CITY OF ALBUQUERQUE

September 25, 2017

**RE: Uptown Assisted Living
7611 Indian School
Requested for Permanent C. O. – Not Accepted
Engineers Stamp Date 11/11/15 (H19D082)
Certification dated: 9-15-17**

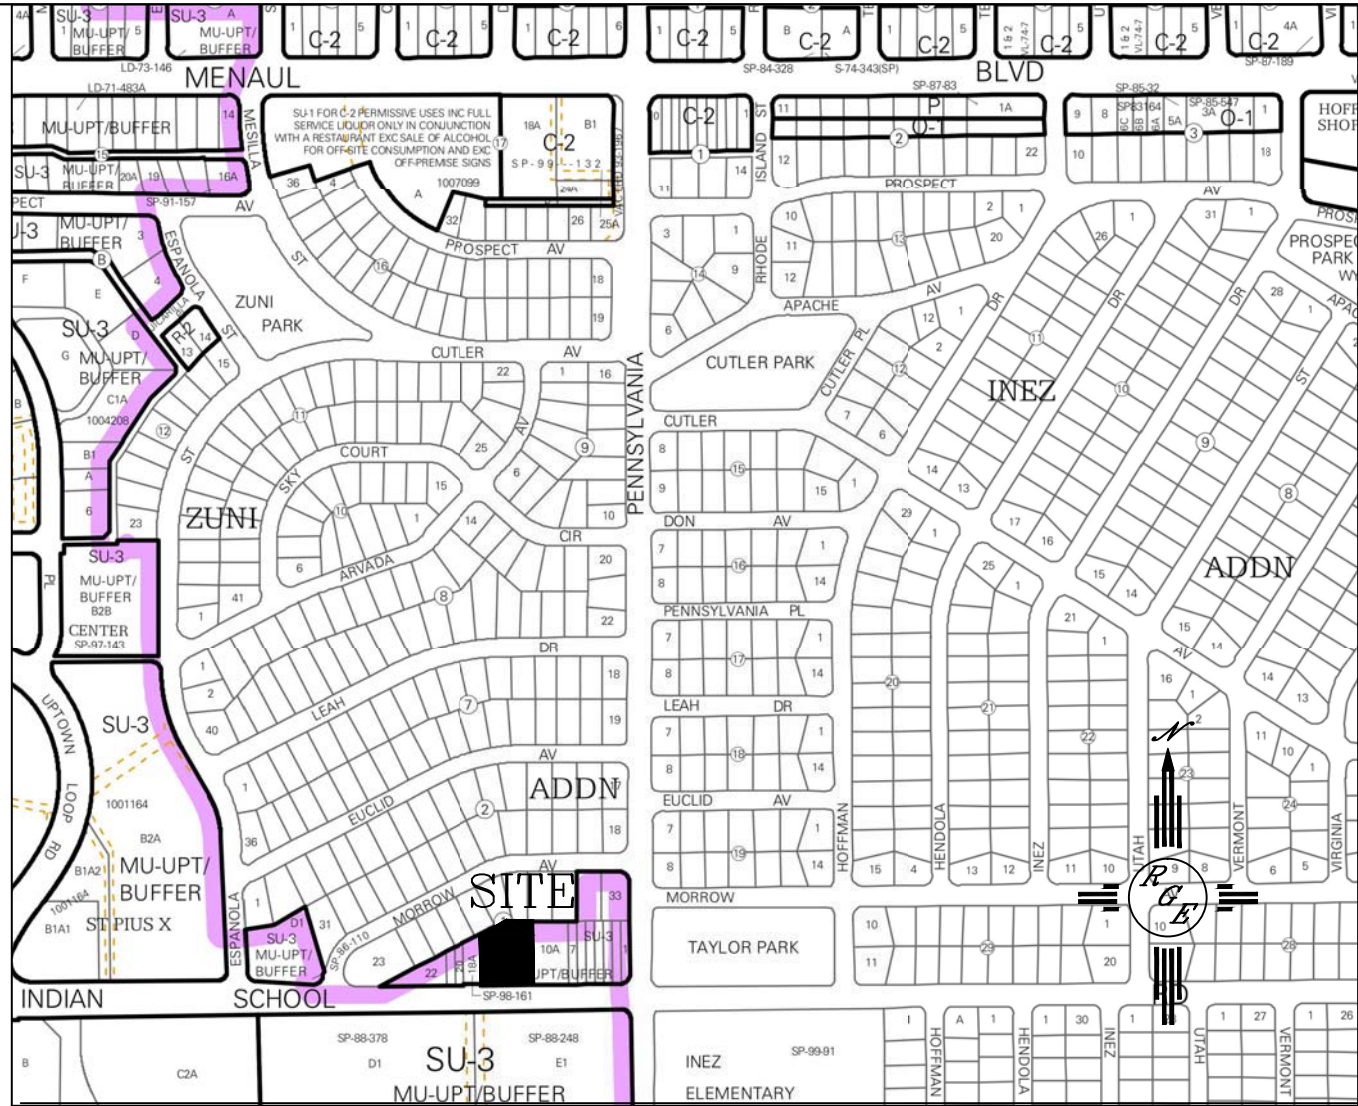
Based on the certification provided in your submittal received 9/15/2017, the above referenced site cannot be accepted for release of Certificate of Occupancy by Hydrology.

Doug, thank you for your comment. There was an asphalt curb on the adjacent lot but either time or this construction has made the curb insufficient to keep flow from overtopping and coming onto our site. My client is going to construct a concrete header curb on the property line. Since this is new, I will need to update the certification and resubmit. Thank you for pointing this out and giving me the opportunity to correct. I believe you are implementing a deadline on resolving submittals, so if you need to my last certification should be rejected. I will be resubmitting in a few days and will send picture so a second field visit may not be required.
